Ref: D2011/628

**COCA COLA AMATIL PLASTICS MANUFACTURING FACILITY
– Construction and Operation; Application Number: 10_0125**

I refer to your letter received 14 December 2010 inviting the Sydney Catchment Authority (SCA) to make a written submission on the Environmental Assessment (EA) for the Coca Cola Amatil Plastics Manufacturing Facility.

UP TO 4750 CRIB WALL SPECIFICATIONS :

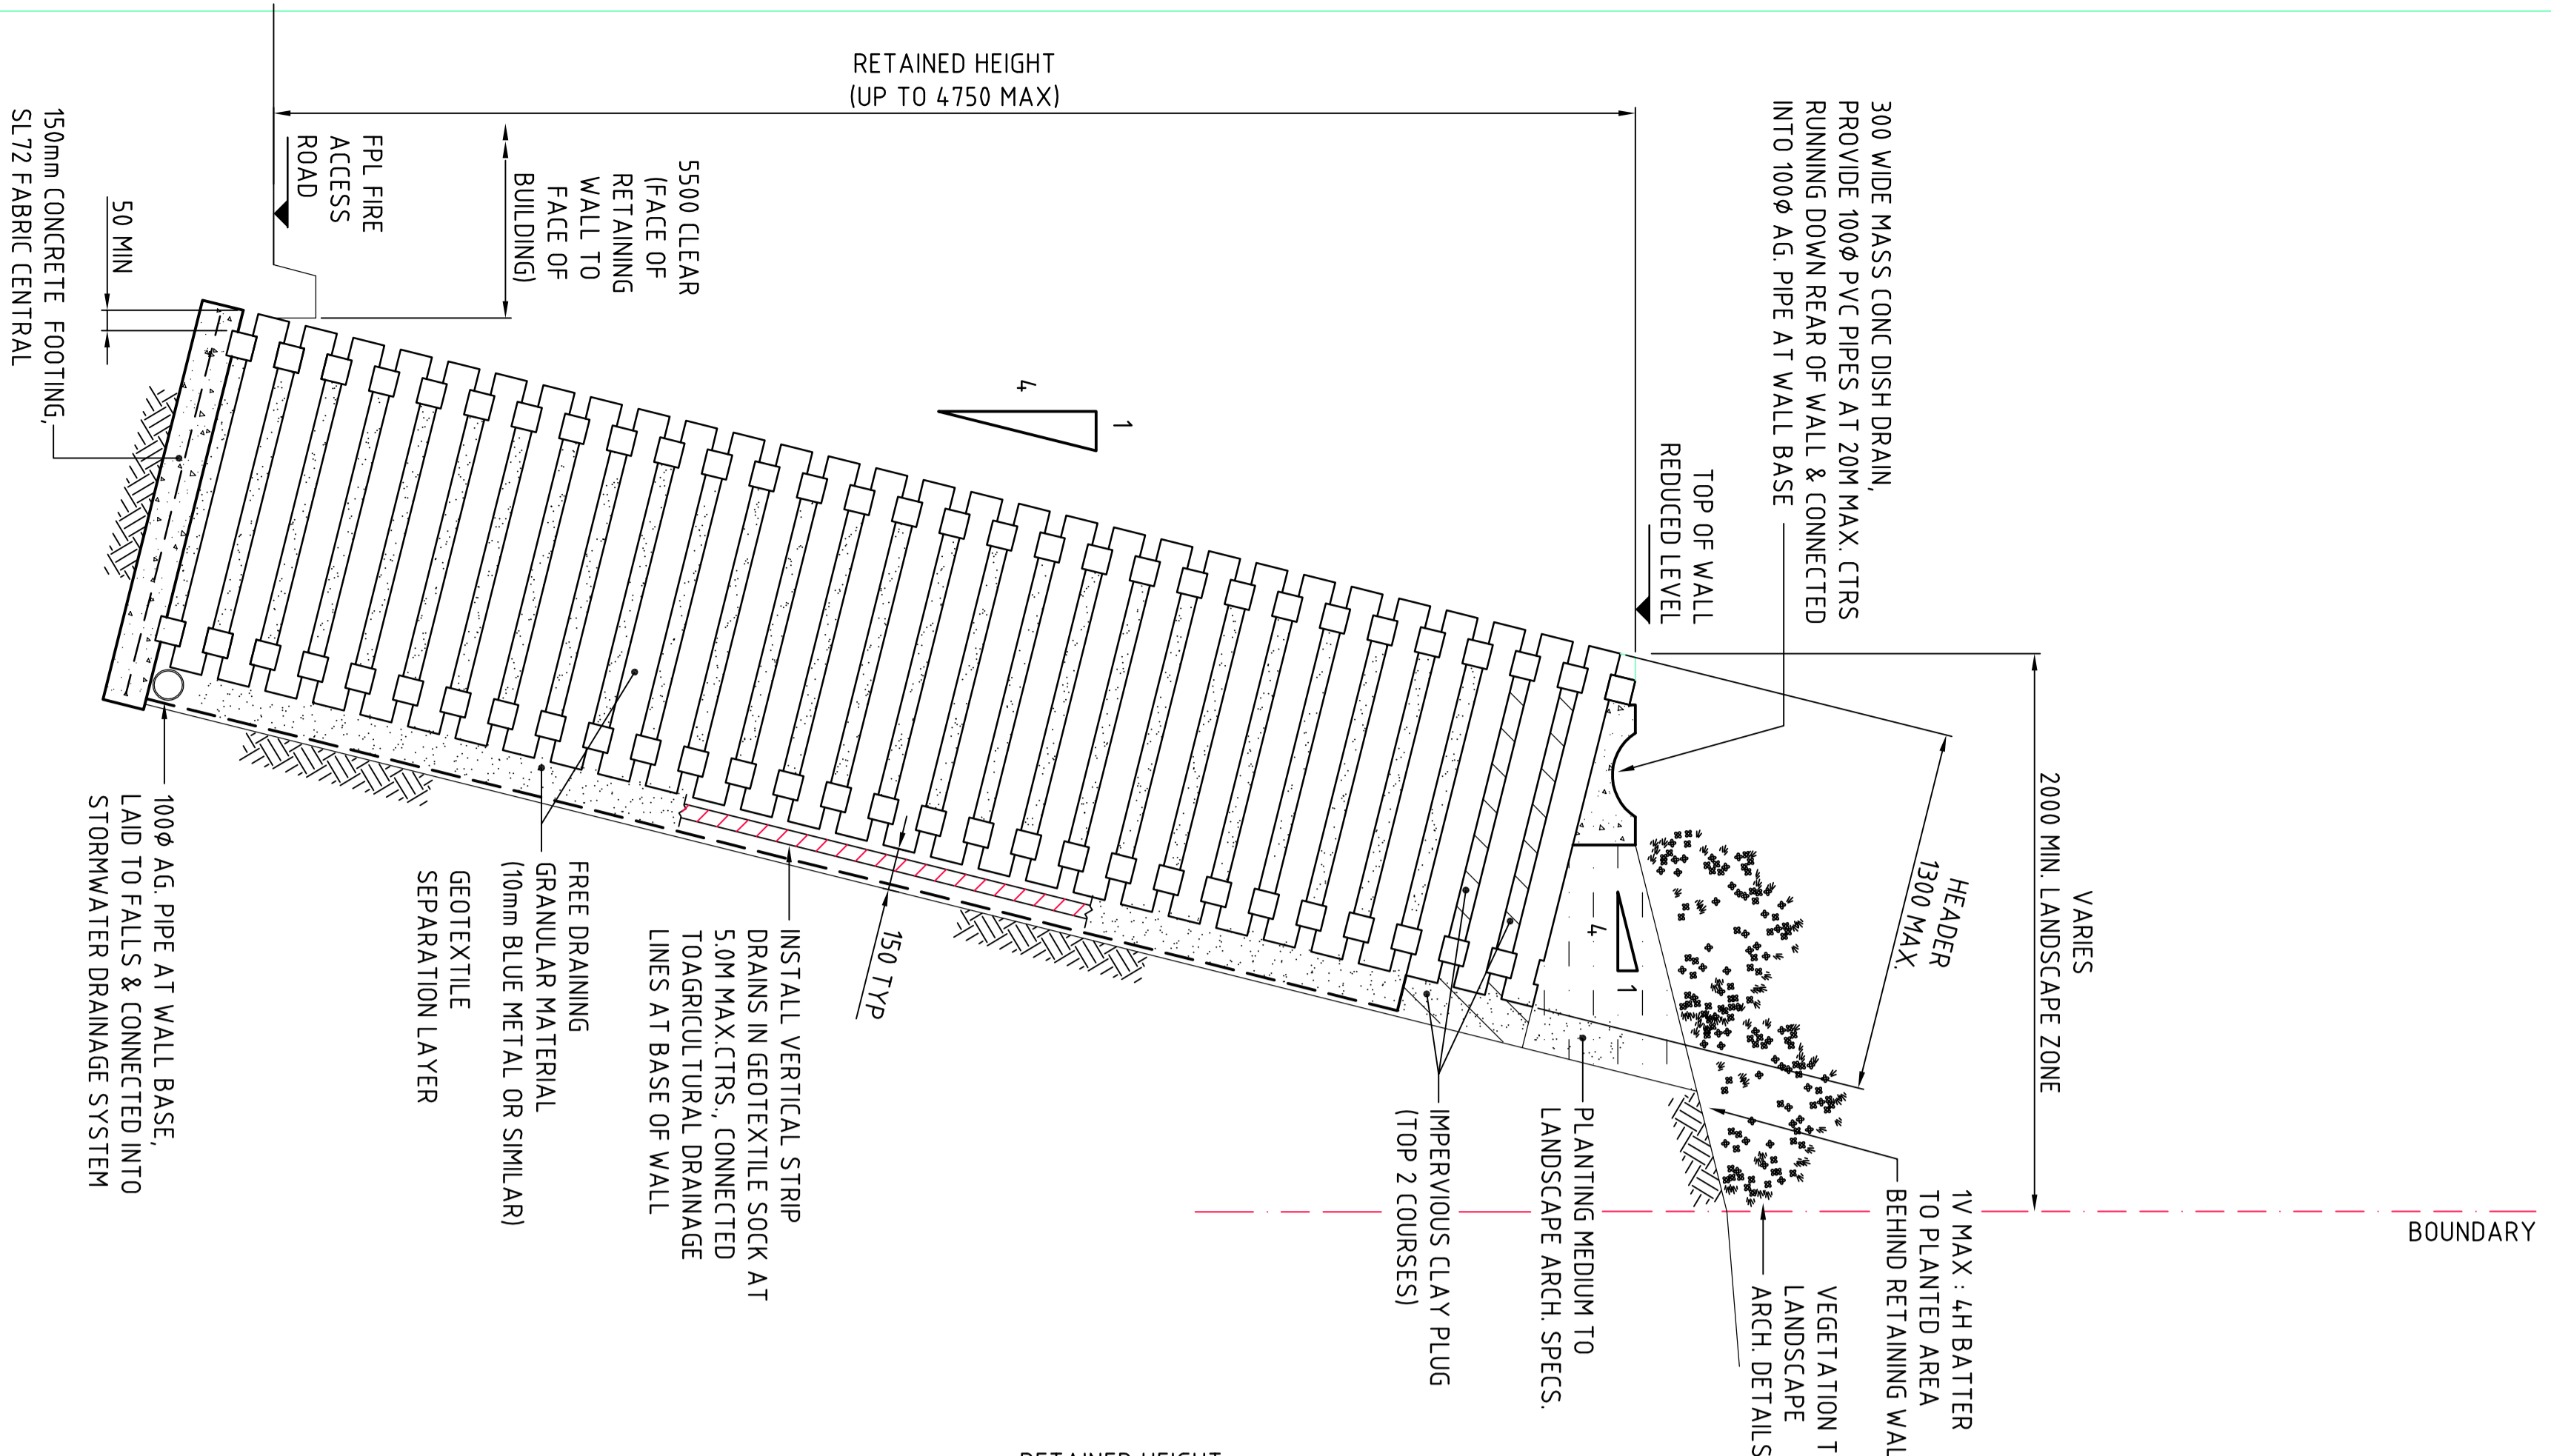
The concept layout plan (No. Co9170.05-CSK02) displayed in Appendix 13 proposes a retaining wall along the boundary fence along SCA land. The SCA requests that the following condition be included in any approval of the development:

- *all work in relation to the retaining wall along the boundary fence along SCA land is constructed in a manner consistent with the drawings provided;*
- *work is undertaken solely within land owned by the proponent. SCA does not permit any entry on SCA land without prior specific approval;*
